Applicant:	Tom Federle	Date:	
Address:	36 Atlanta	C-B-L:	16-E-002
Permit #:

CHECKLIST AGAINST ZONING ORDINANCE

(Front view)

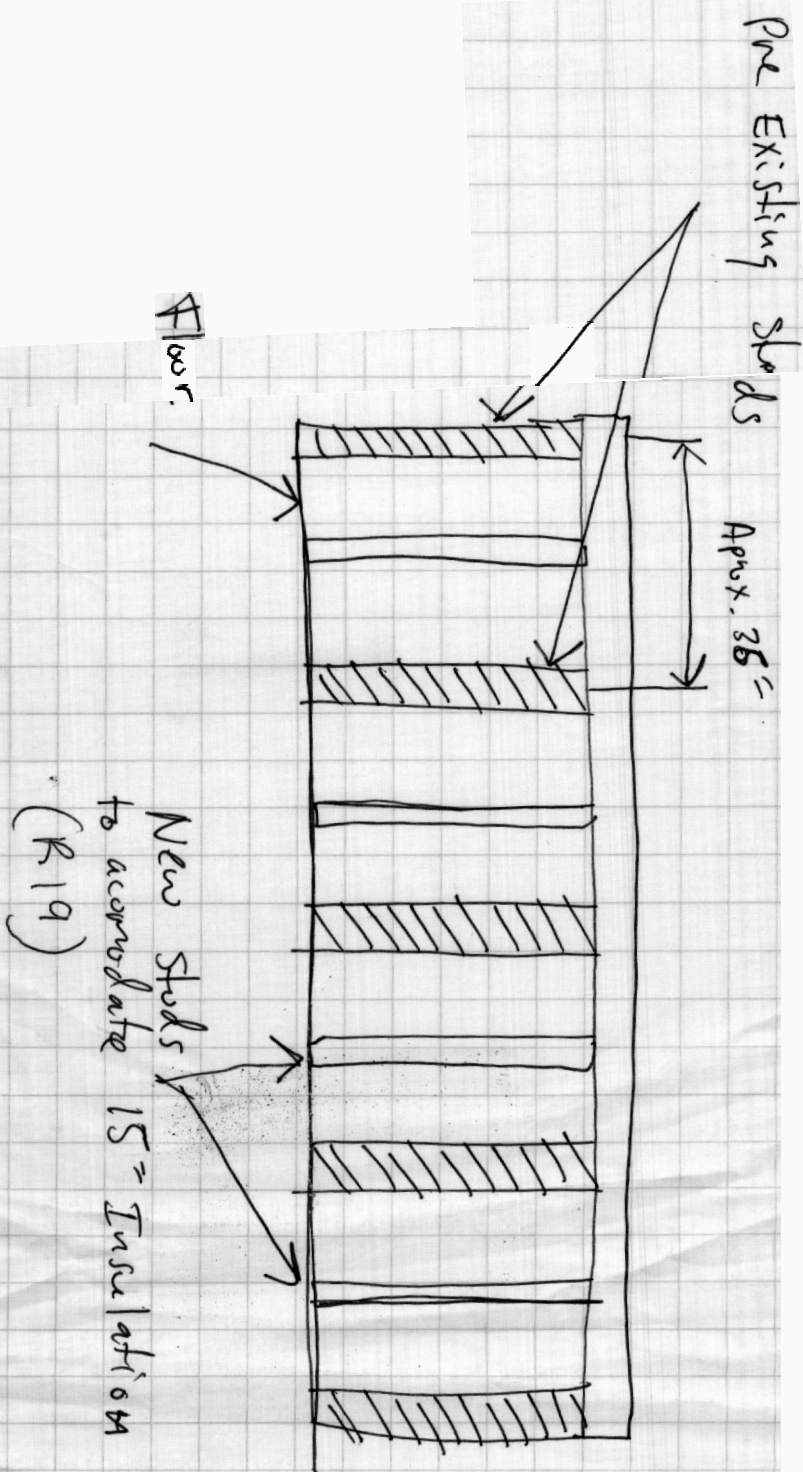
- ① needs to address 5' right side setback of deck
- ② proposed 50' deck can't extend more than 6' - 14-425
